REQUEST

Current Zoning: MUDD-O (mixed-use development-optional)
Proposed Zoning: MUDD-O SPA (mixed-use development-optional, site plan amendment)

Approximately 1.23 acres located in the northeast quadrant of the intersection of Central Avenue and Morningside Drive, south of Roland Street.

The petition proposes to amend a previously approved plan permitting 44,000 square feet of nonresidential uses (with an allowed maximum of 24,000 square feet of retail and EDEE type uses) to increase total square footage to 45,000 square feet and allow residential as a permitted use.

RZP # 2022-224  
OFFICE AND RETAIL  
CENTRAL AVENUE AND MORNINGSIDE DRIVE  
2609 CENTRAL AVENUE

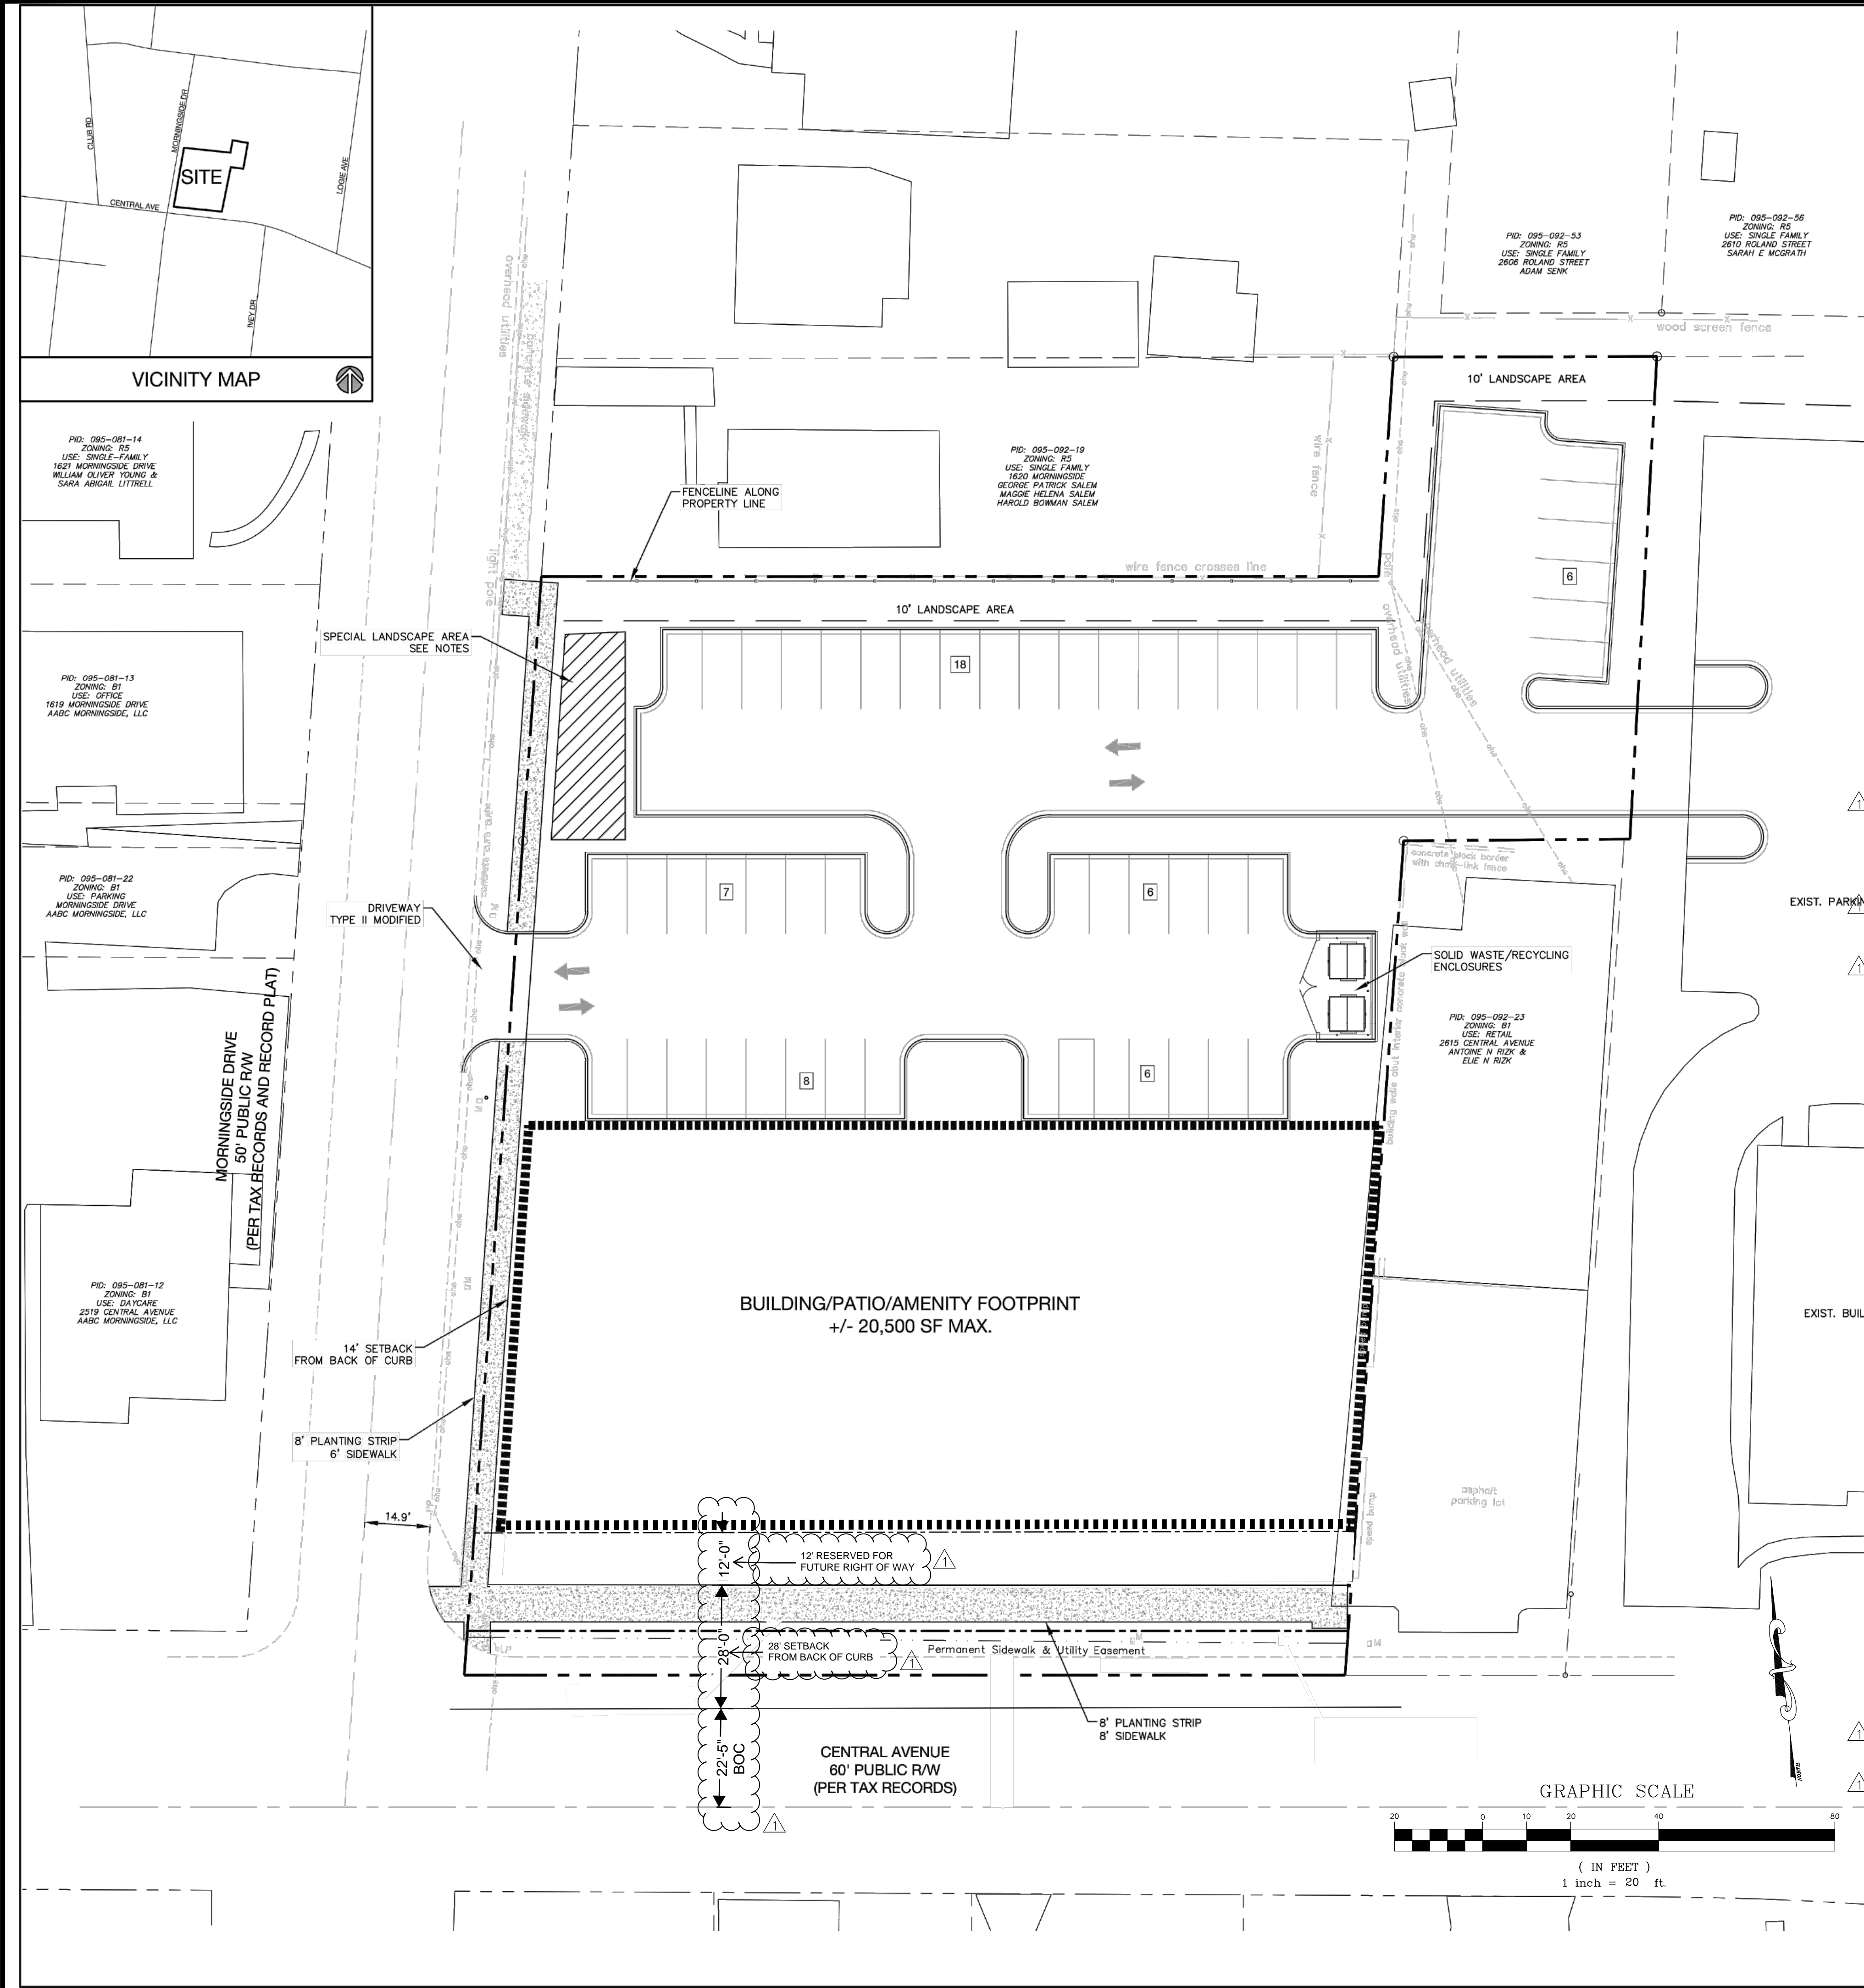
2. Curblines:
 - a. Central Avenue: Location of curb and gutter to be moved to 32.5 feet from roadway centerline to accommodate the Charlotte Streets Map with a roadway typical section of 4 Avenue with Buffered/Separated Bike Lanes.
 - b. Morningside Drive: The future location of curb and gutter is in its existing location.
NOTE: Additional distance from center line to back of curb may be required in locations where a median is present or around intersections and interchanges.

Label and dimension the curb and gutter from the centerline for each road on the site plan.

3. Revise site plan and conditional note(s) to commit to dedicate 50.5 feet of right-of-way from the Central Avenue Road centerline. The site plan shall label and dimension the right-of-way from the road centerline. Comment 11-27-23: Please add a label and dimension showing right-of-way dimension mentioned on site plan and revise conditional note(s) to commit to previously mentioned right-of-way dimension.
4. Add a conditional note specifying "the Petitioner shall dedicate and convey in fee simple all rights-of-way to the City before the site's first building certificate of occupancy is issued. CDOT requests rights-of-way set at 2' behind back of sidewalk where feasible."

5. Modify optional provisions C and D to ensure expansions are limited to no more than 1,000-1,500 square feet.
